**Re: Innova Plaza South Building,
401 Eubank Blvd. SE Albuquerque, NM
Request for Certificate of Occupancy
Transportation Development Final Inspection**
Engineer's/Architect's Stamp dated 03-03-2017 (L20D067)
Certification dated 02-12-2018

Based upon the information provided in your submittal received 11-21-2018, Transportation Development will issue a 30-day Temporary Certificate of Occupancy based solely on the Traffic Certification dated 02-12-2018. This letter serves as a "green tag" from Transportation Development for a 30-day Temporary Certificate of Occupancy to be issued by the Building and Safety Division.

REVISION DATE

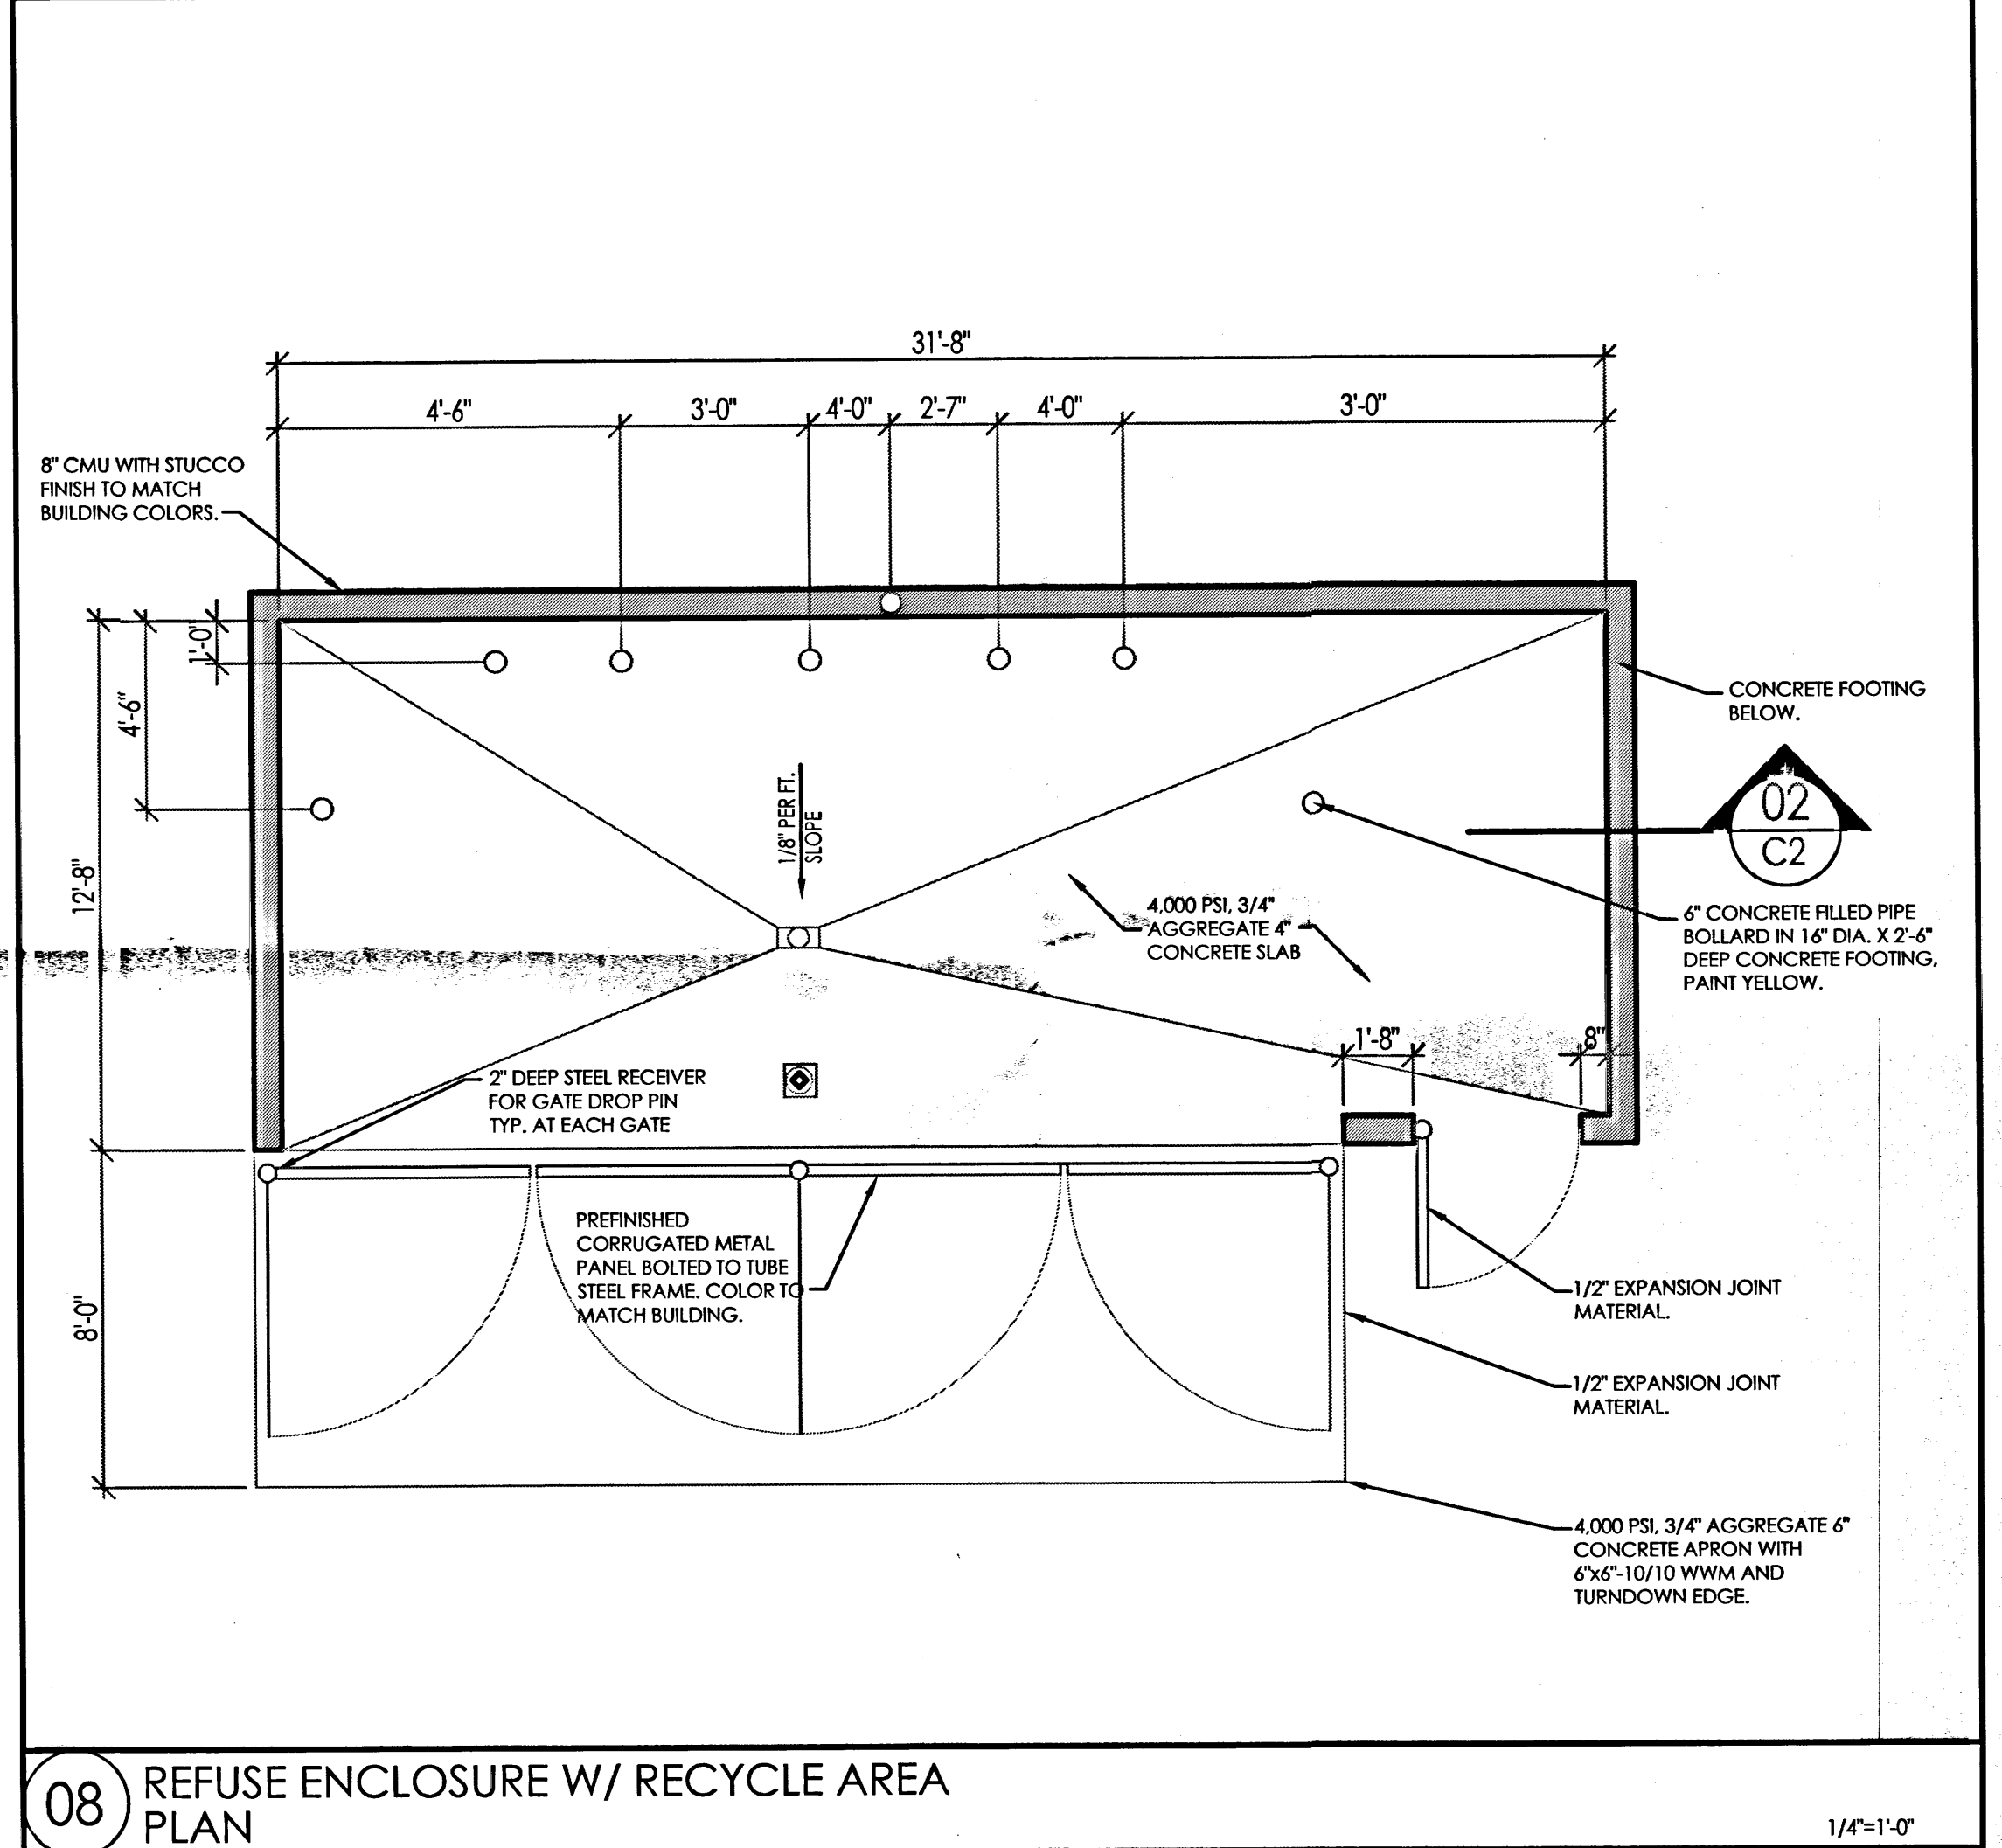
- Please clear the site of all the debris
- Please install a pedestrian access connecting the side walk to the building the same way it was approved in the original submittal on 03-14-2018.
- Please make sure all the striping are the same as the original submittals.
